Addendum to Arboricultural Impact Assessment

**Land at Crow Trees Farm,
Crow Trees Brow, Chatburn,
Lancashire, BB7 4AA**

**ADDENDUM TO ARBORICULTURAL IMPACT ASSESSMENT
LAND AT CROW TREES FARM, CHATBURN**

Date of Issue: 25 June 2026

CLIENT	Pringle Homes				
PROJECT	Proposed Residential Development at				
	Crow Trees Farm, Crow Trees Brow, Chatburn, Clitheroe, Lancashire, BB7 4AA				
DRAWING	Proposed Boundary Treatment Details				
DRAWN	JAL	DATE	23/07/25	NUMBER	21/139/BT01
SCALE	Varies	SHEET	A1	REVISION	D

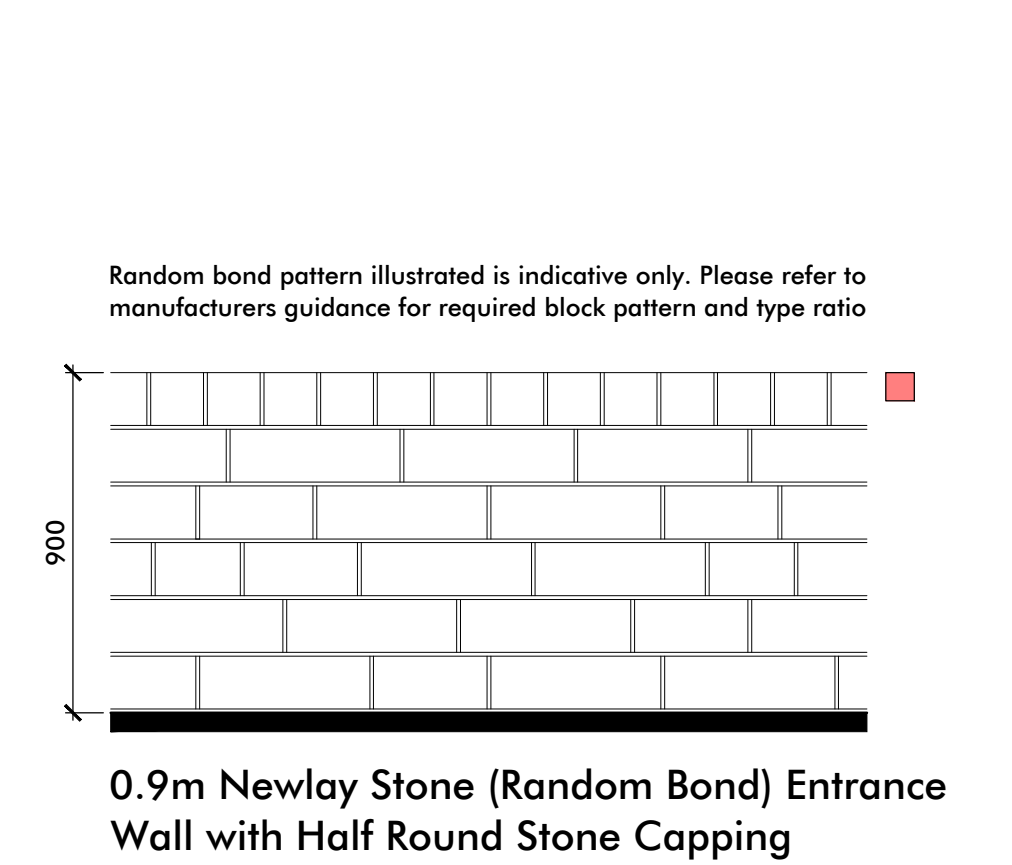
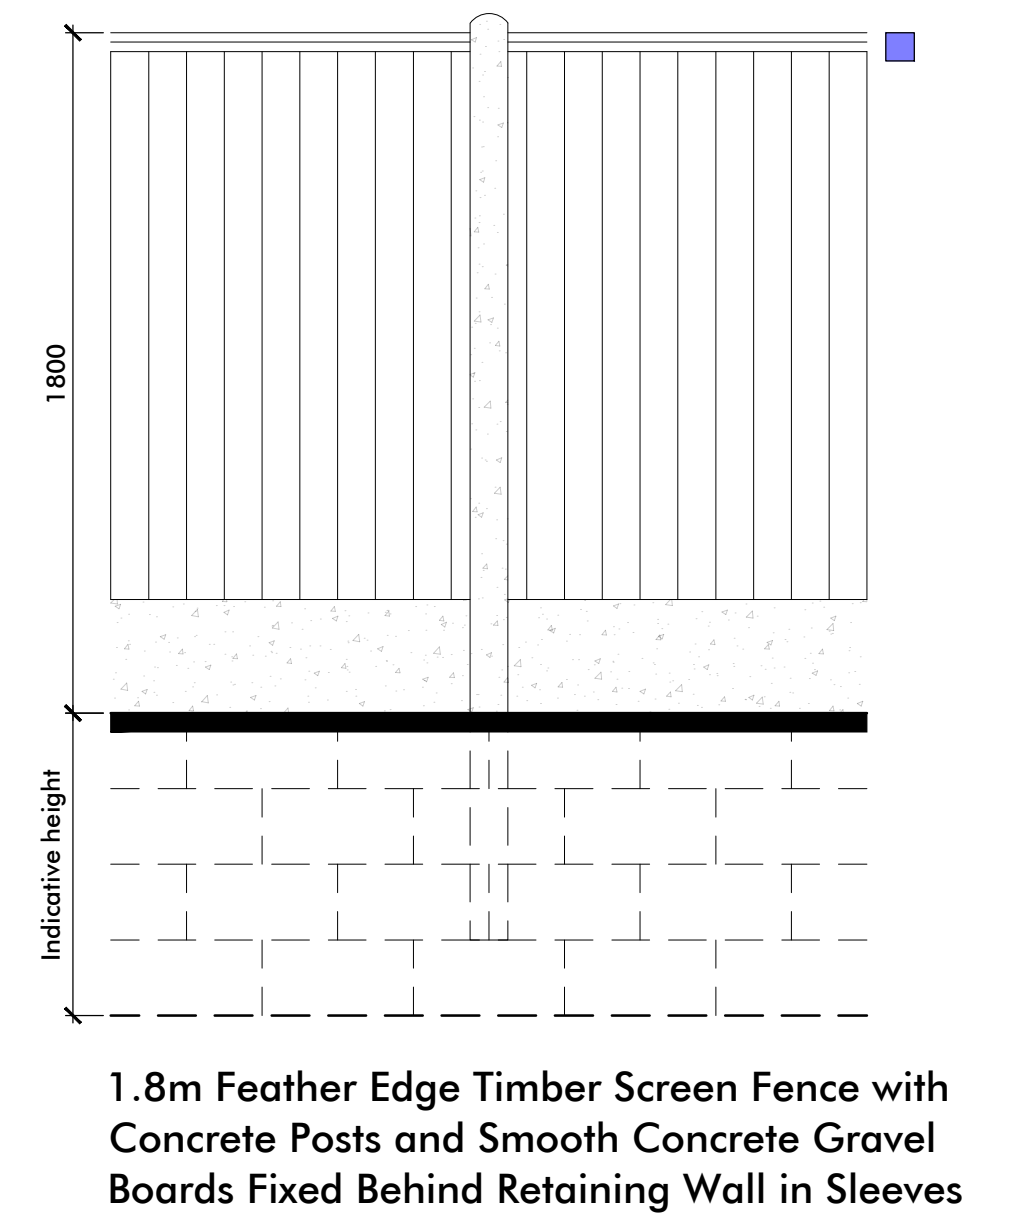
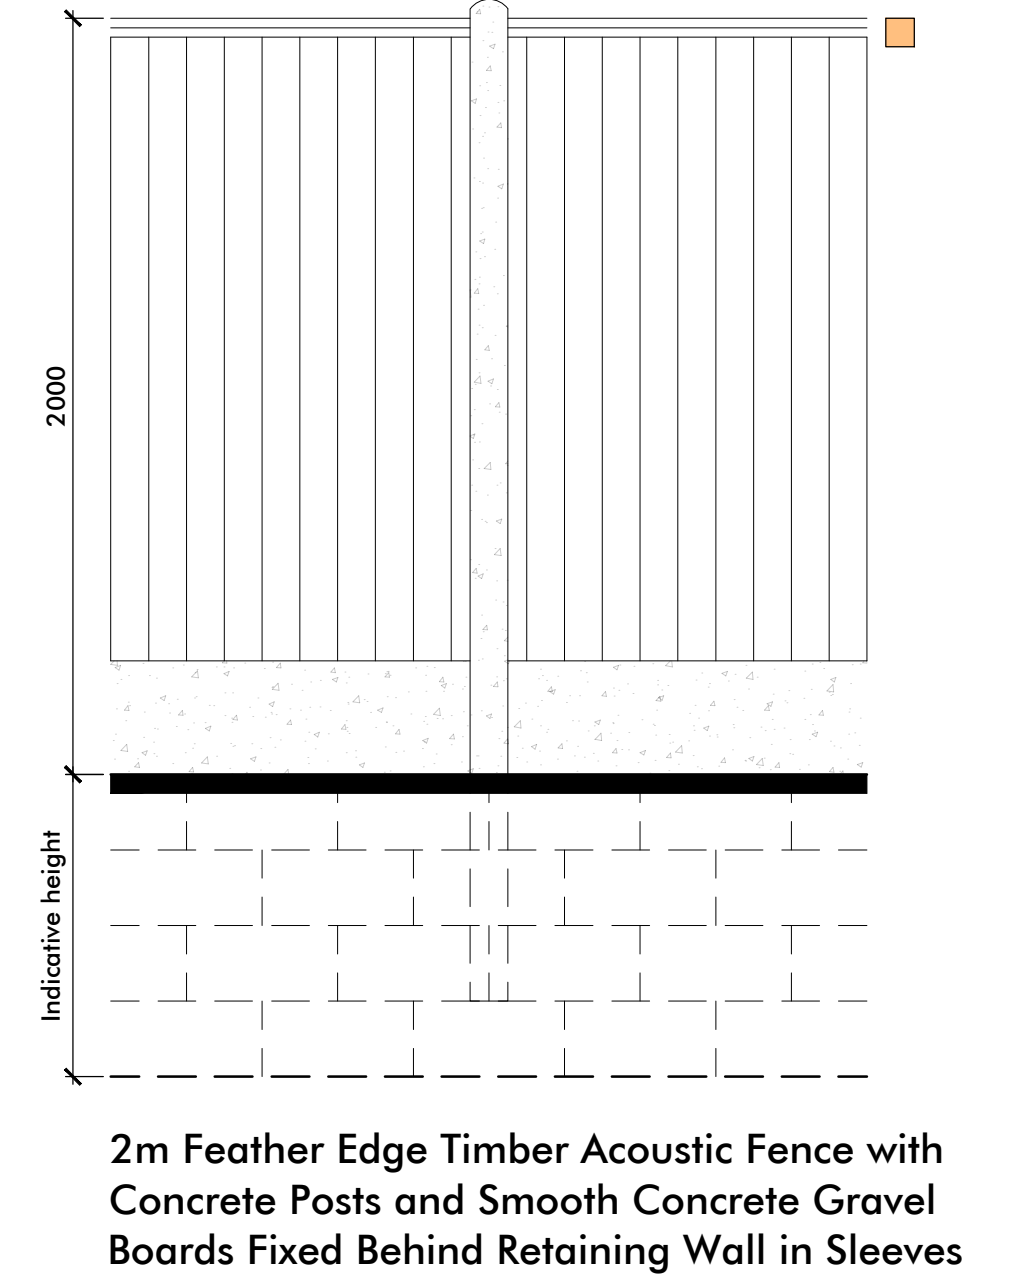
Following review of the revised plans, the proposed bin store and cycle storage locations generally keep outside of the RPAs of adjacent trees T41, T42 and T43. A minimal encroachment into the RPA of T43 from the revised footpath access to the bin store has been noted, with <1% of encroachment into the total RPA of T43 and comprising a very small encroachment at the very outer edge of the RPA

Whilst some very minor encroachment for a small section of the path may occur, **roots in this area of RPA** are considered likely to be of smaller diameter, and relatively insignificant in relation to maintaining the overall structural and physiological condition of the trees. As such, minor pruning works to any such roots, if/where required, is not projected to cause any significant long term structural and/or physiological impacts to the retained trees, providing the foundations to the footpath section which encroach into this area are completed by hand tools only, as opposed to excavators which could risk further damage to roots outside of the encroachment area.

As the bin store is in proximity to the RPAs of T41, T42, and T43, the construction of the concrete post and timber boarded fencing should also be completed by hand digging the post holes, with no machinery entering the RPAs of the adjacent trees to avoid unnecessary soil compaction within unsurfaced ground of these areas.

The bases of the footpath and bin store and cycle shelters pads are to be constructed with flagged hardstanding with 150mm deep MOT base; a 1.8m high close boarded timber with concrete base fencing will be provided enclosing the bin store area (as previously proposed).

To ensure the trees are not at as risk of negative impacts, the main contractor should ensure tree protection fencing is maintained to these trees in line with measures as stated in the AIA report, (for to completing these areas inclusive of tree protection measures), and to ensure the above information is taken into consideration in the works.
